Application for a non-material amendment following a grant of planning permission.

Single storey rear extension

62600/APP/2021/783

Removing the original small roof on the rear, revising the bifold door and repositining the roof light

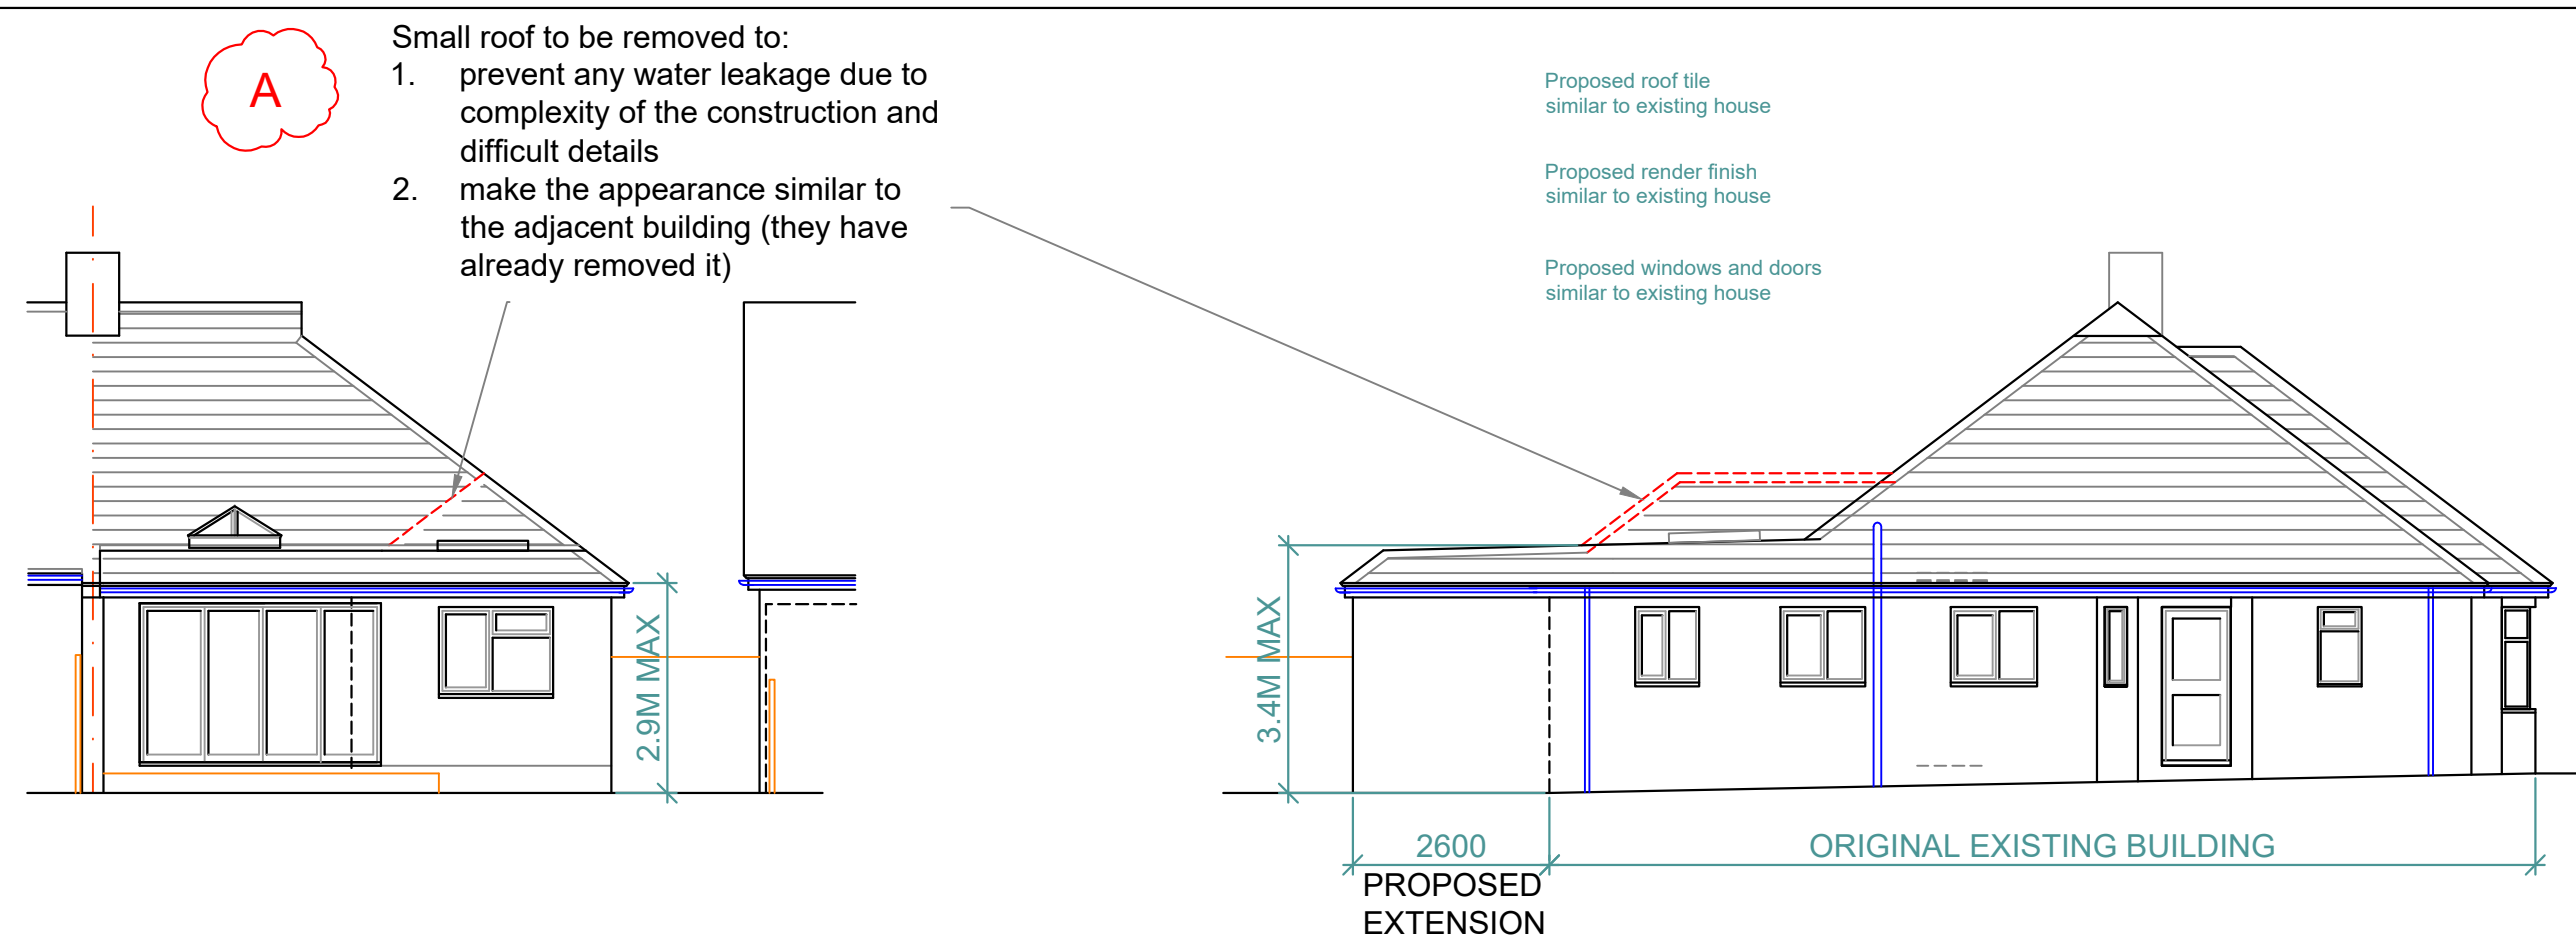
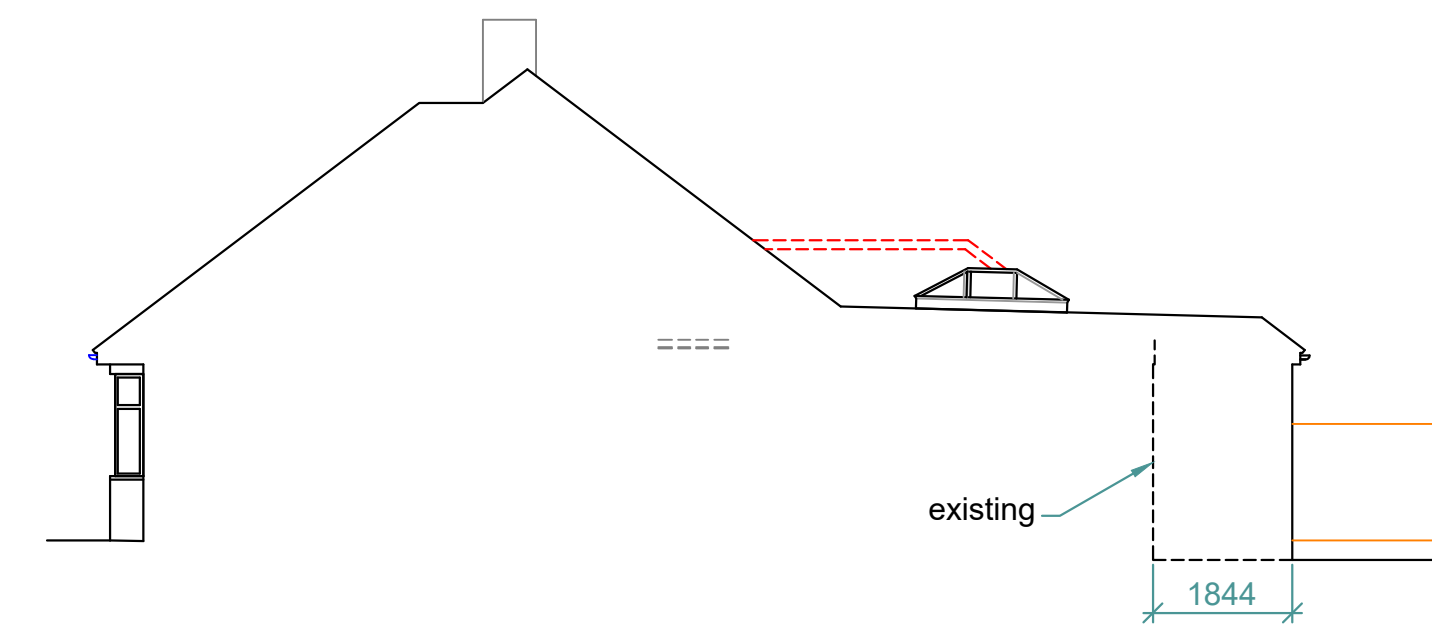
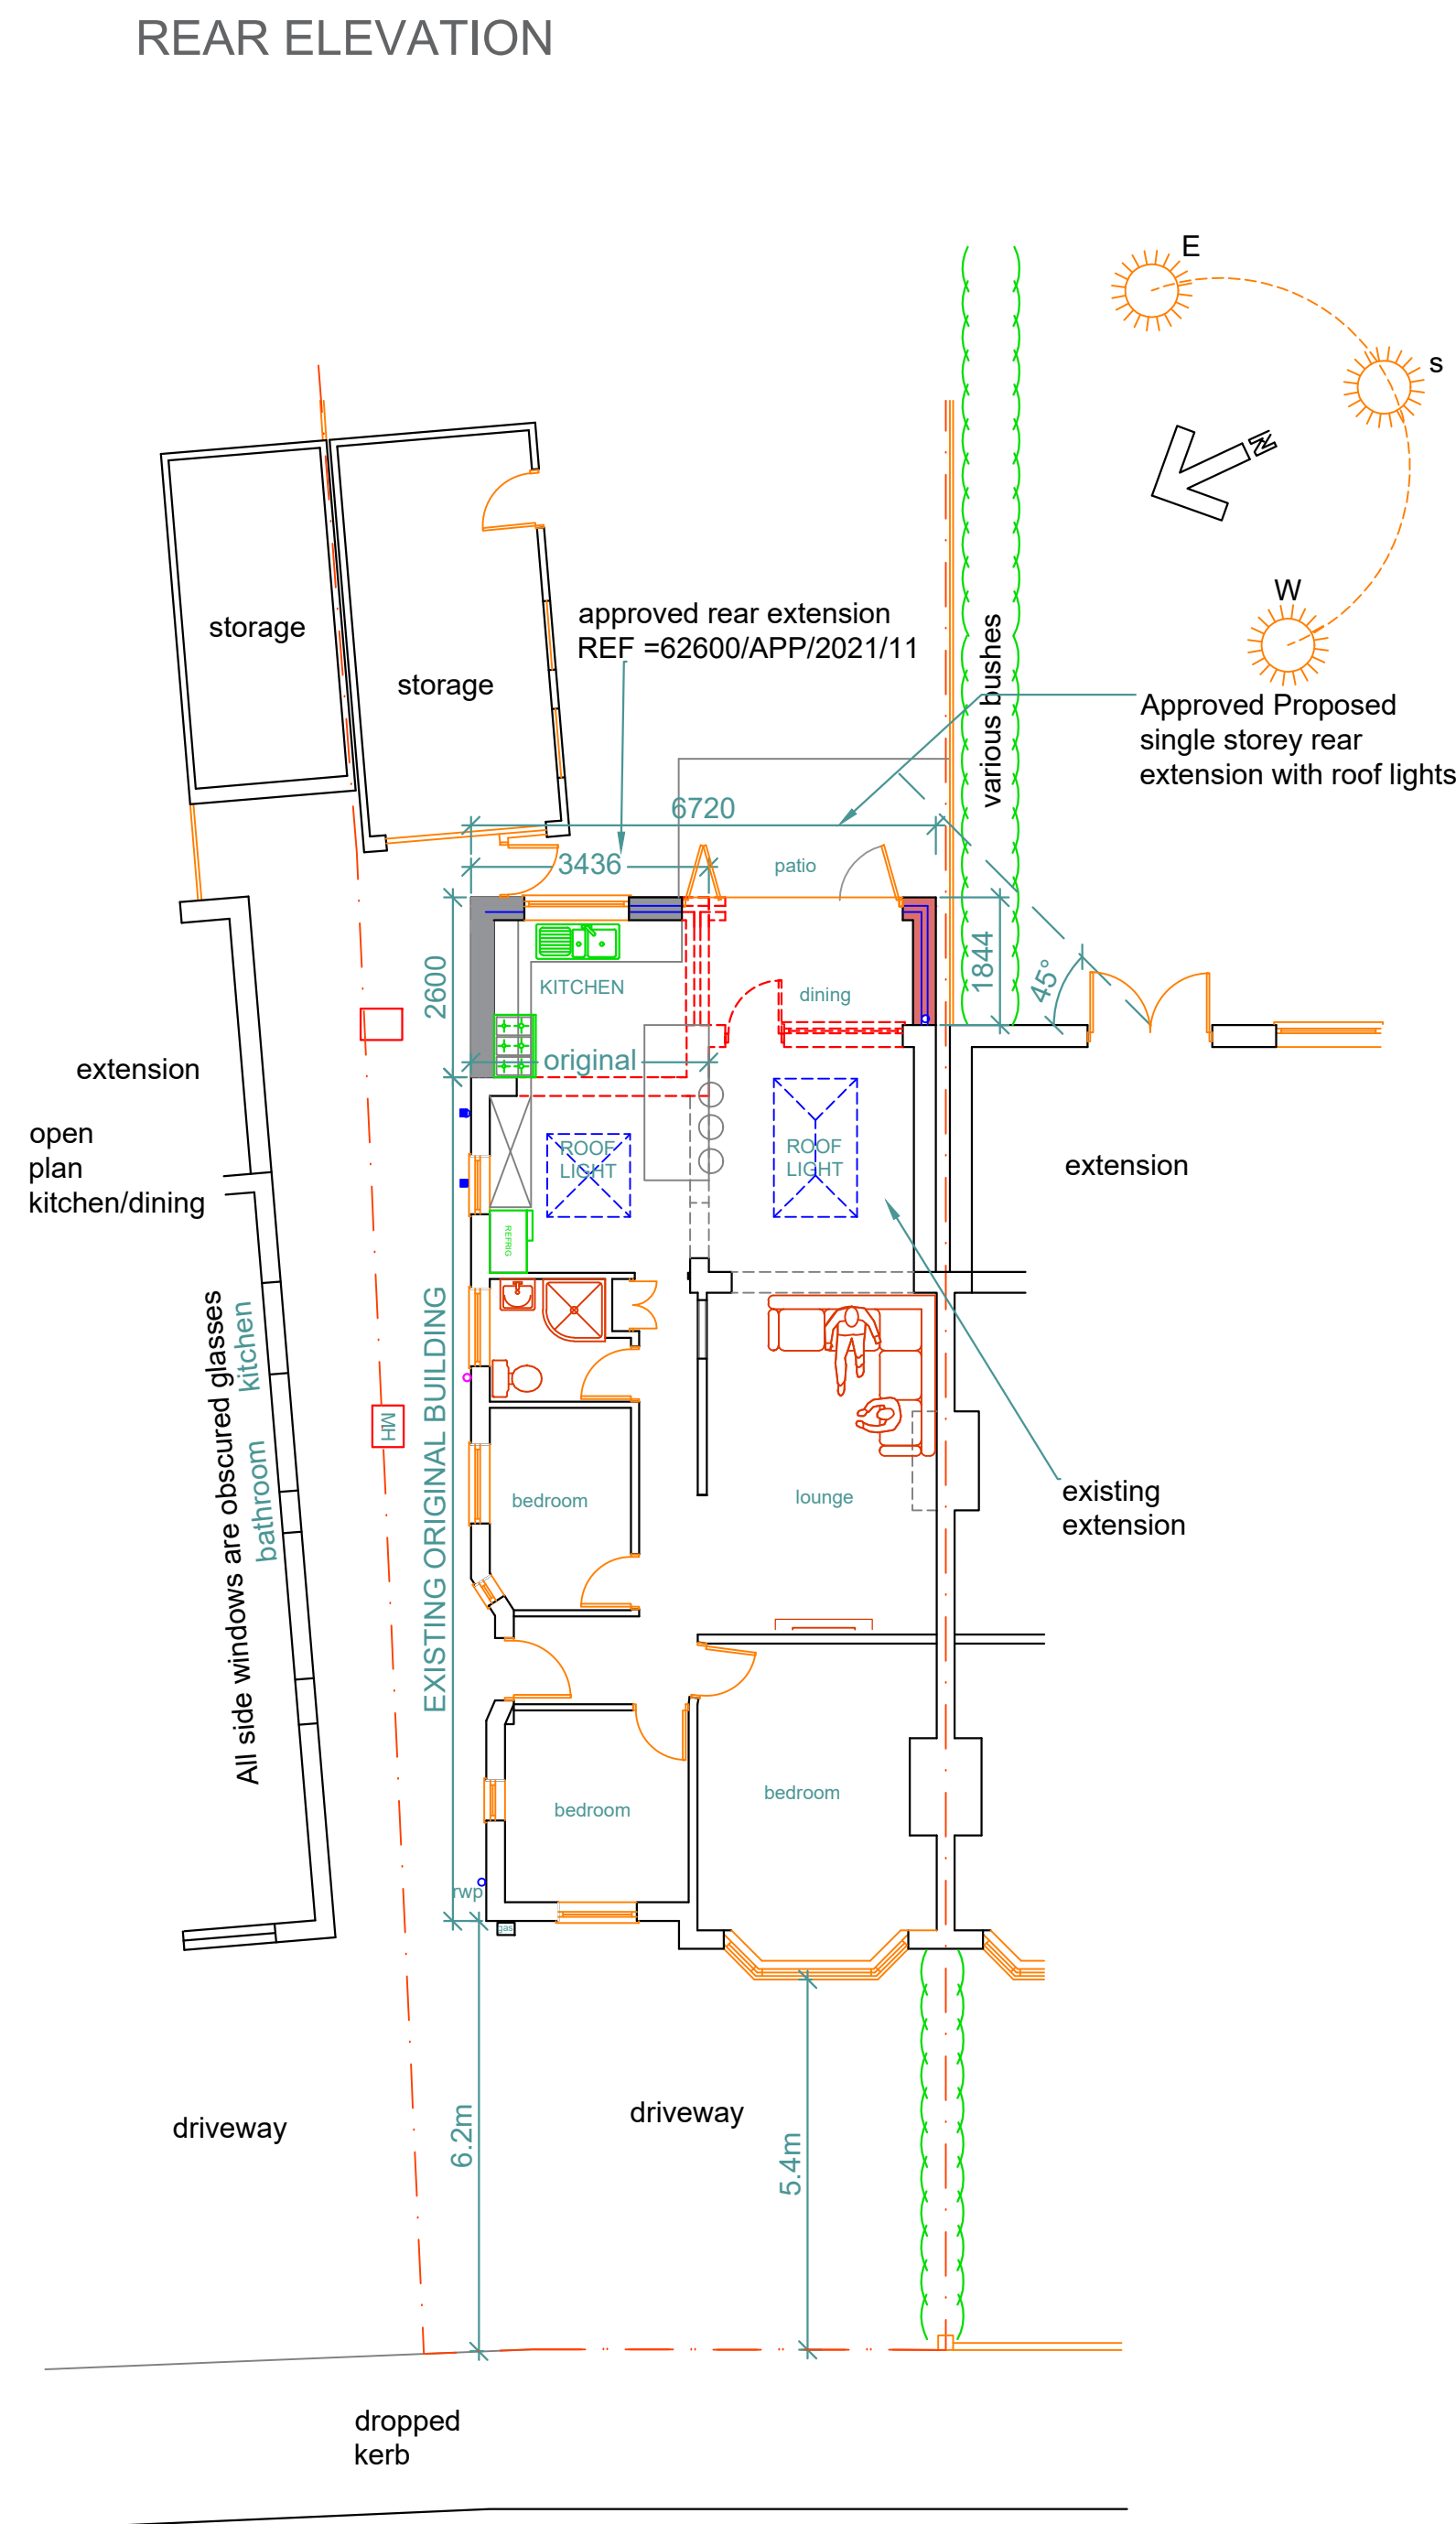
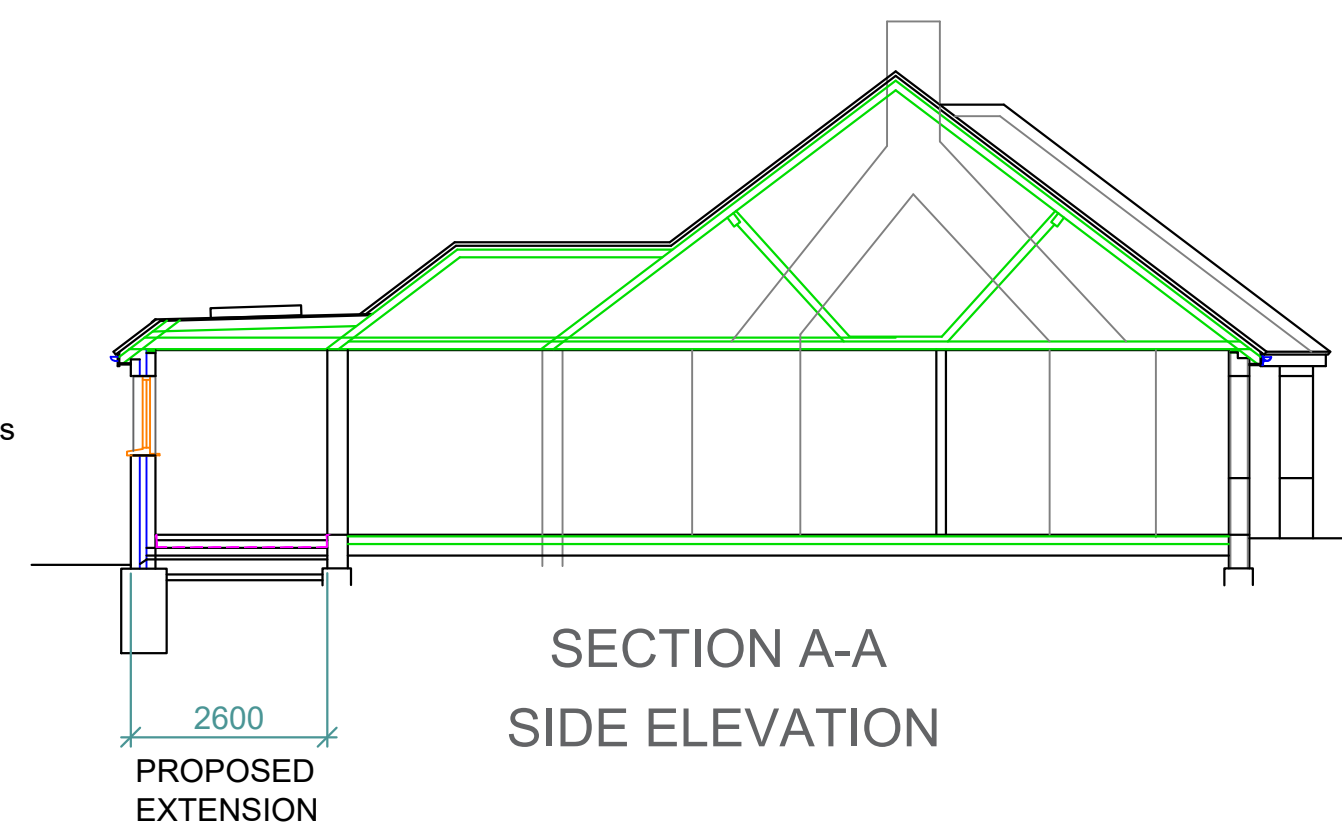
Small roof to be removed to:
1.prevent any water leakage due to complexity of the construction and difficult details
2.make the appearance similar to the adjacent building (they have already removed it)
